Application for a Non-Material Amendment Following a Grant of Planning Permission

Southbourne Gardens

Erection of a single storey rear extension.

63822/APP/2023/3429

Roof Plans

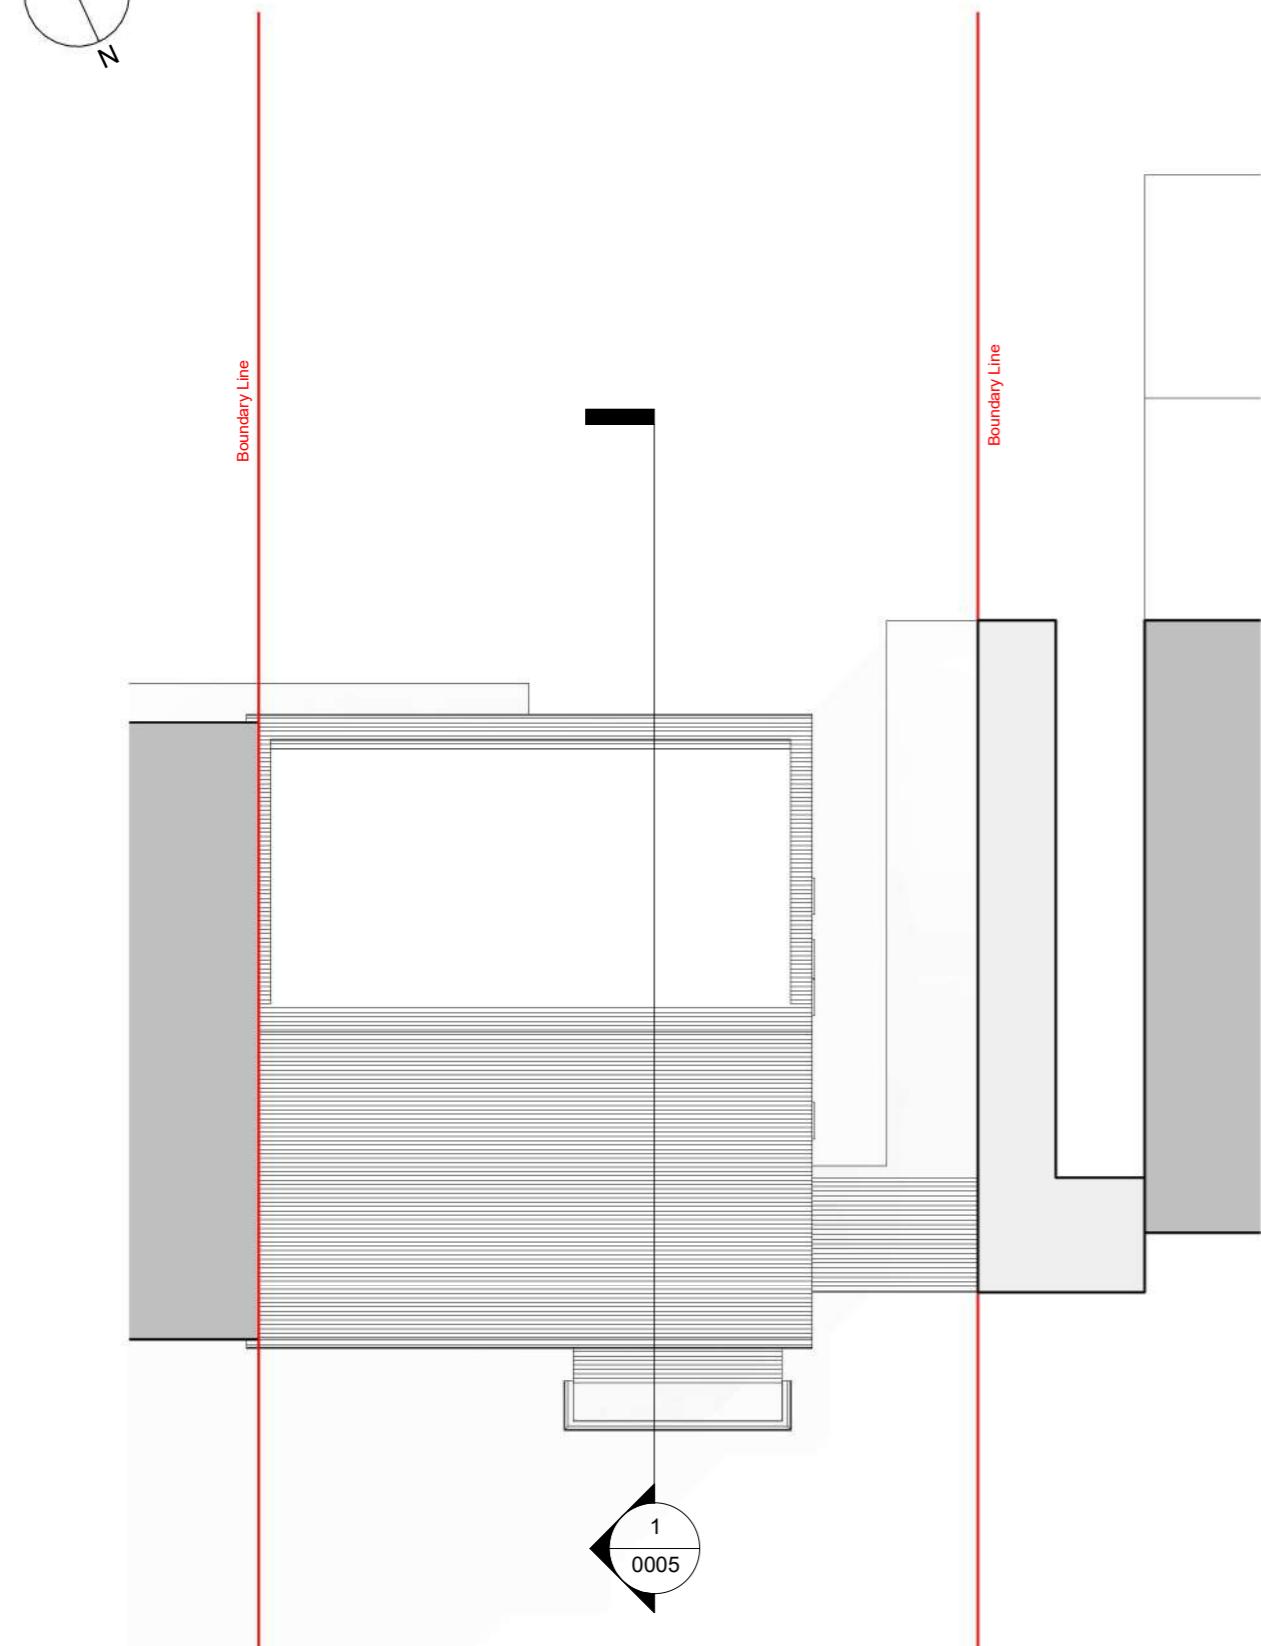
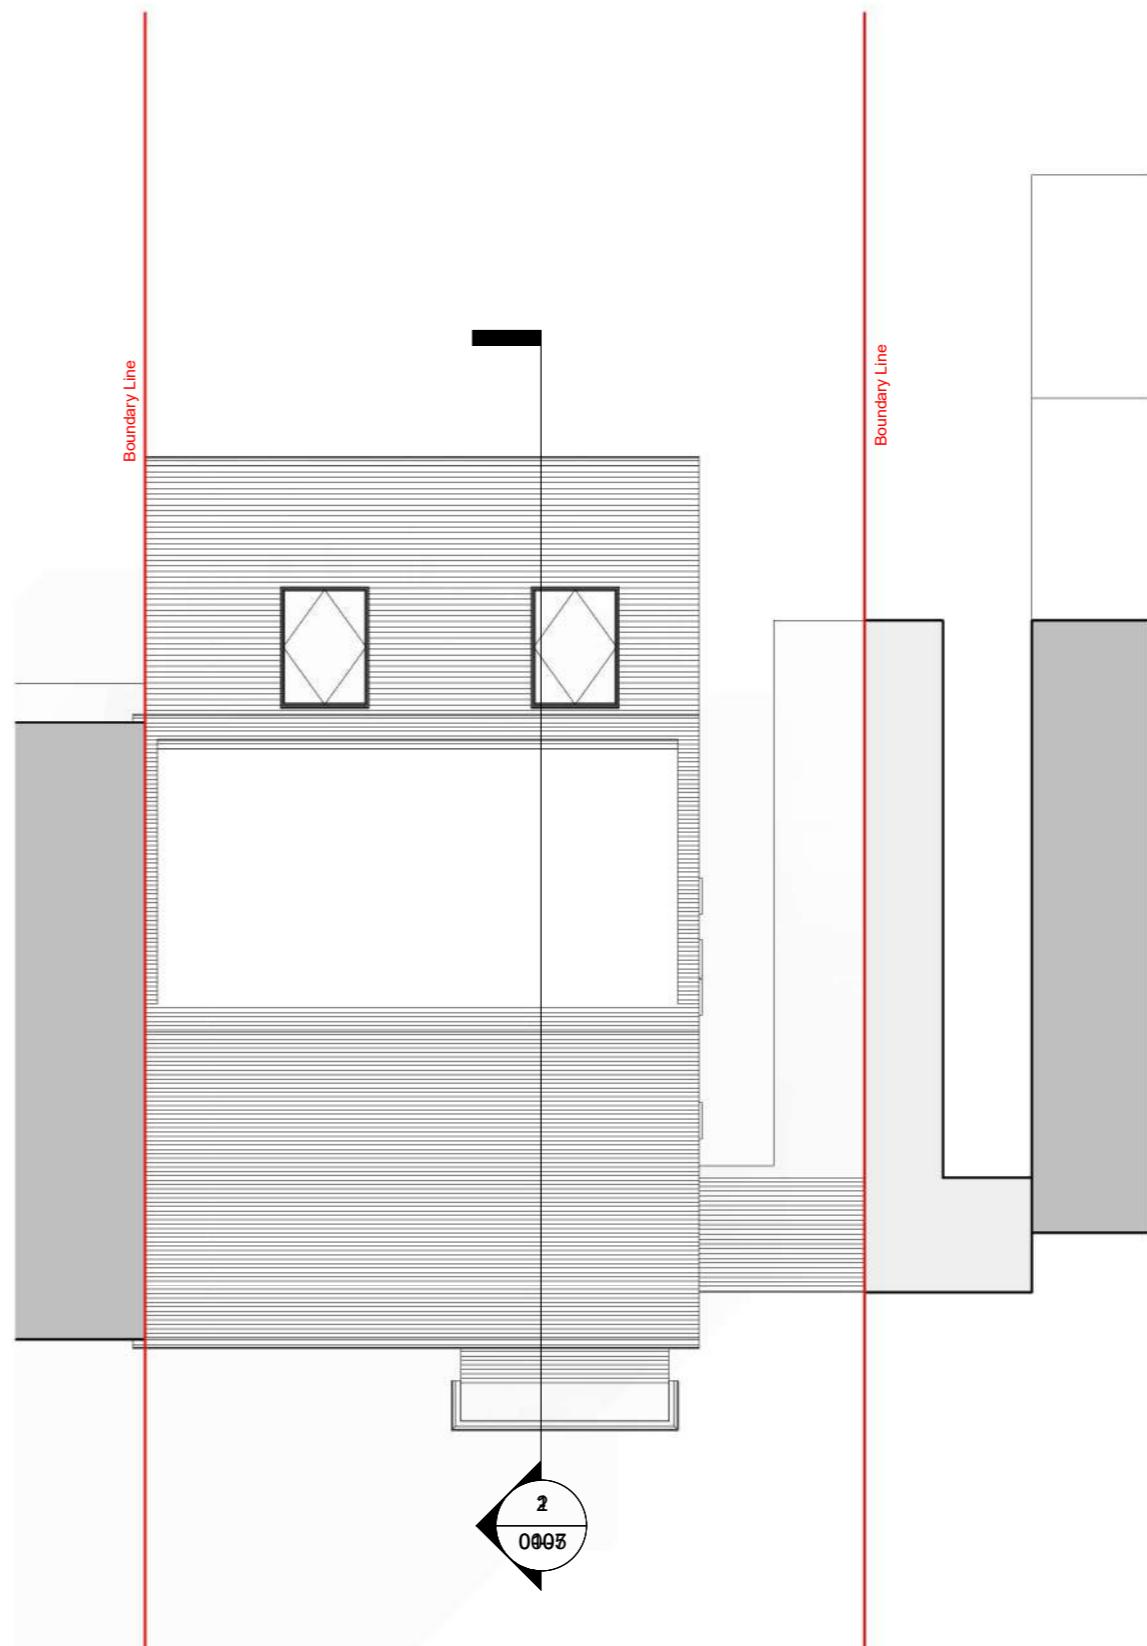
Fenestration change on the rear elevation of the proposed single-storey rear extension.
Additional skylight on the proposed pitched roof.

Changes were made to facilitate an internal layout change.
